# ENG-SF21033-R3-CDs.pdf Markup Summary

**Subject:** Callout  
**Page Index:** 15  
**Date:** 8/25/2022 5:15:10 PM  
**Author:** Daniel Torres  
**Color:** ■  
**Layer:**  
**Space:**  
**Page Label:** [15] 15 Estacado Place

**CL- ESTACADO PLACE PROFILE
STA 99+50.00 TO 105+30.40**

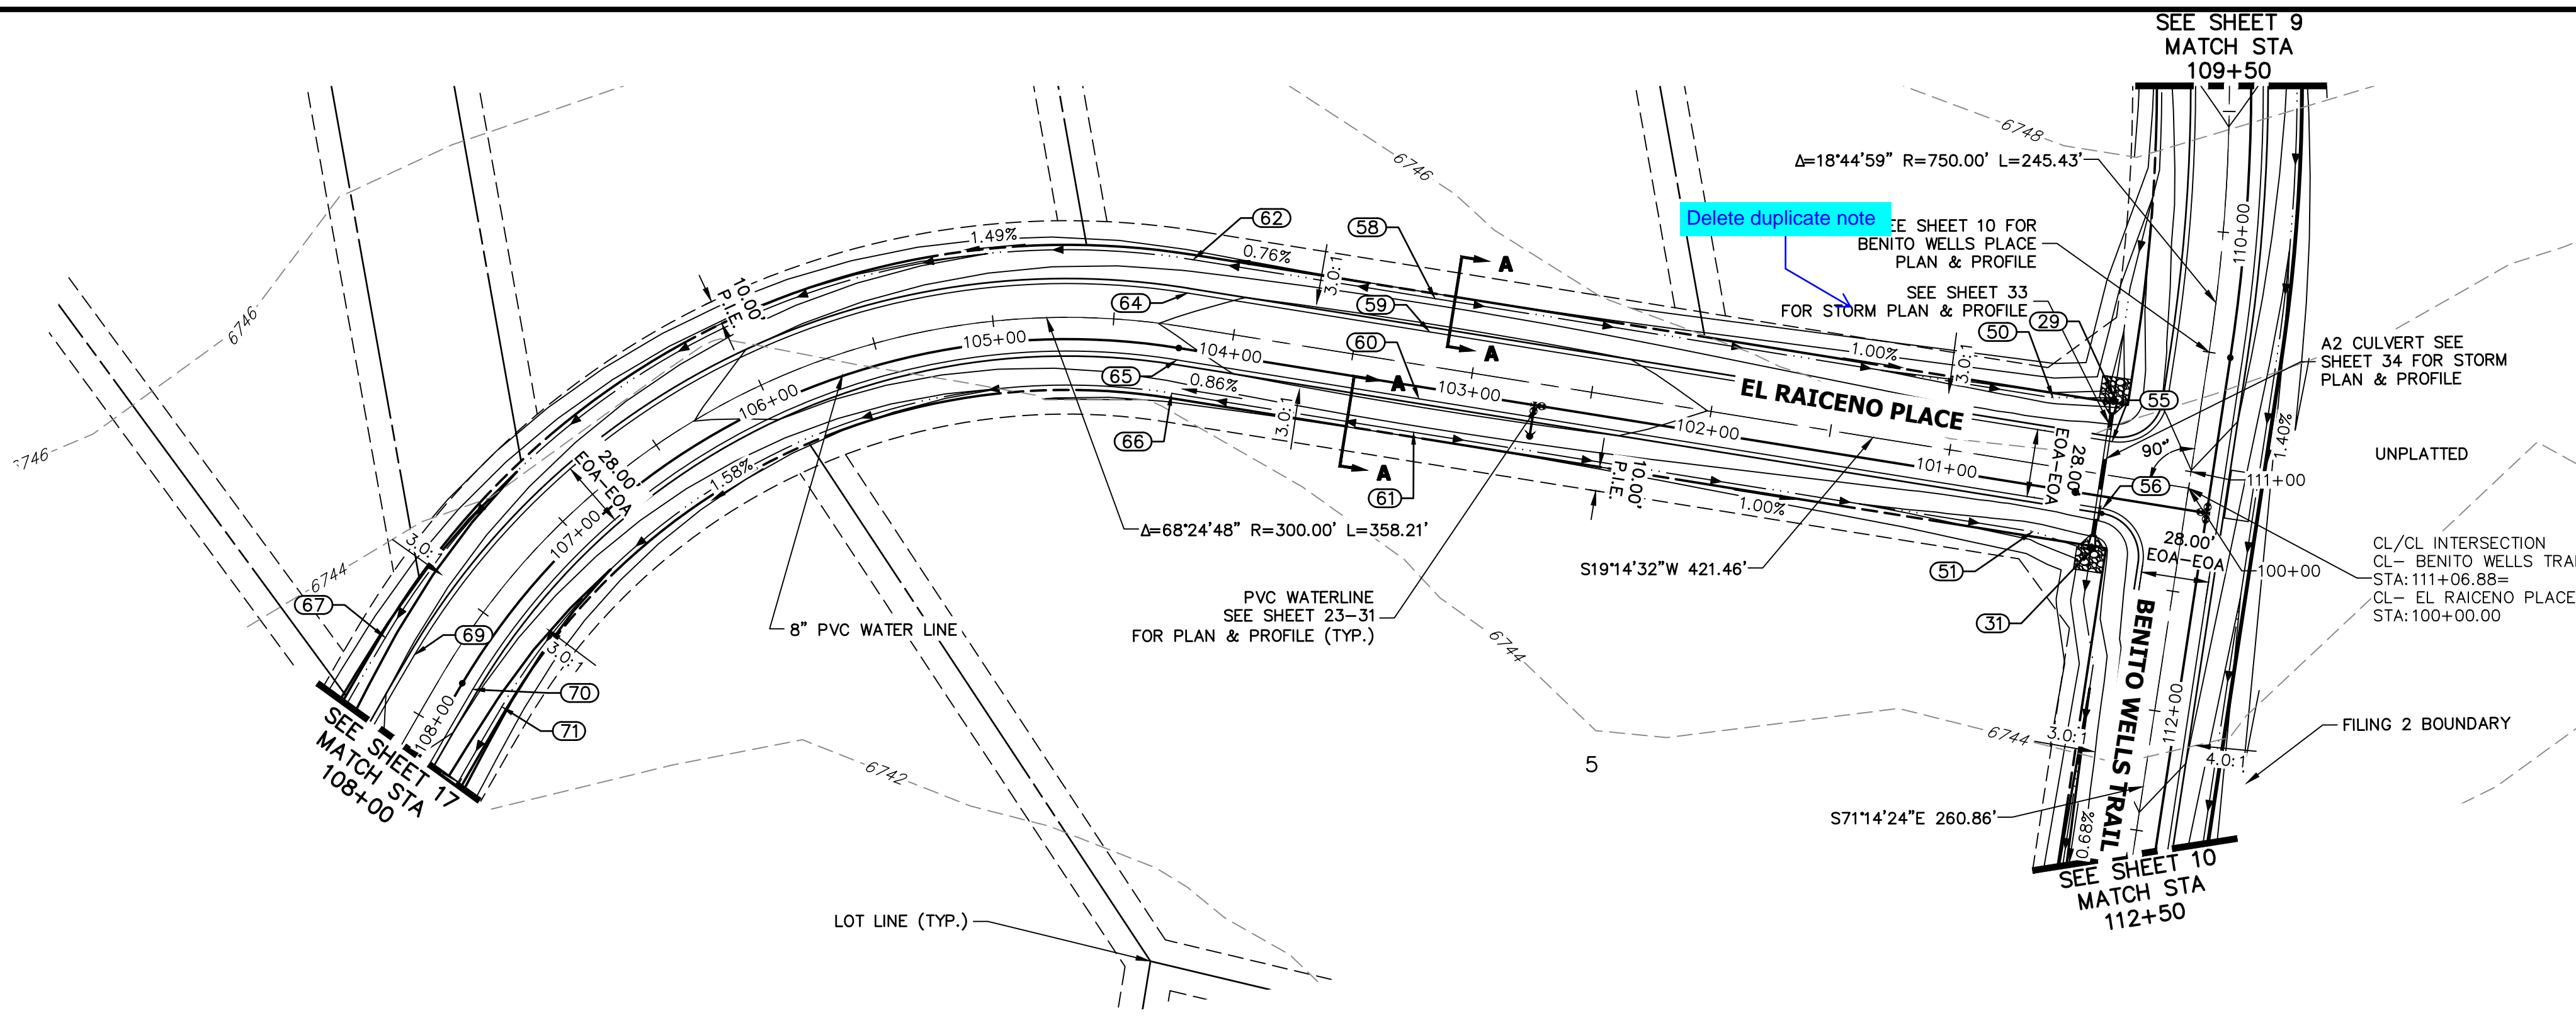
Review 1:  
Min K-value for 30 mph rural road is 37

Review 2:  
Unresolved

Review 3: unresolved

**CL- EL RAICENO PLACE PROFILE
 STA 100+00.00 TO 108+00.00**

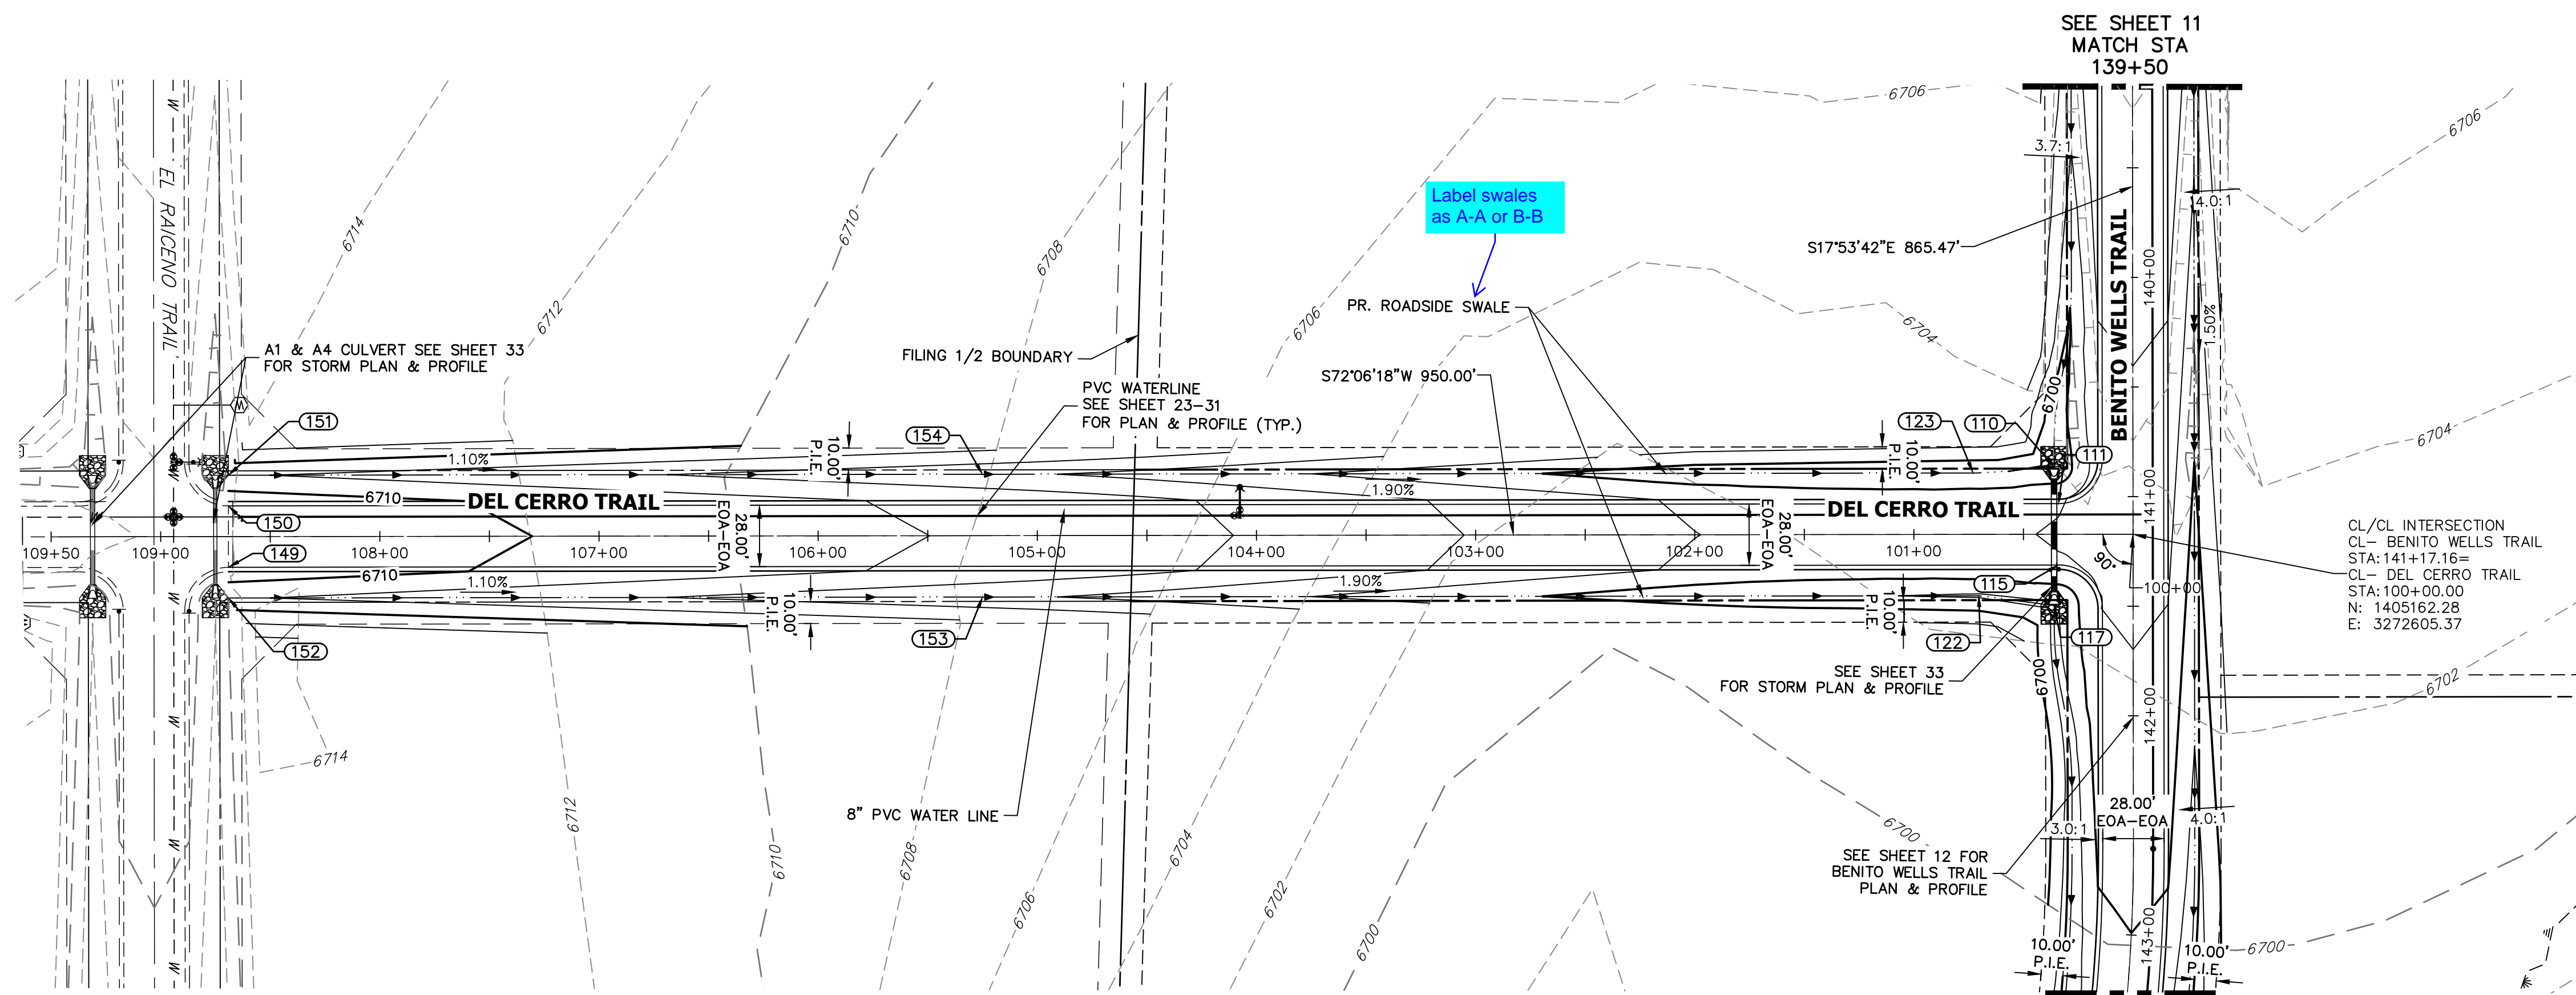
Review 1:  
Min K-value for 30 mph rural road is 37 & fix text rotation

Review 2:  
Unresolved

review 3:  
Unresolved
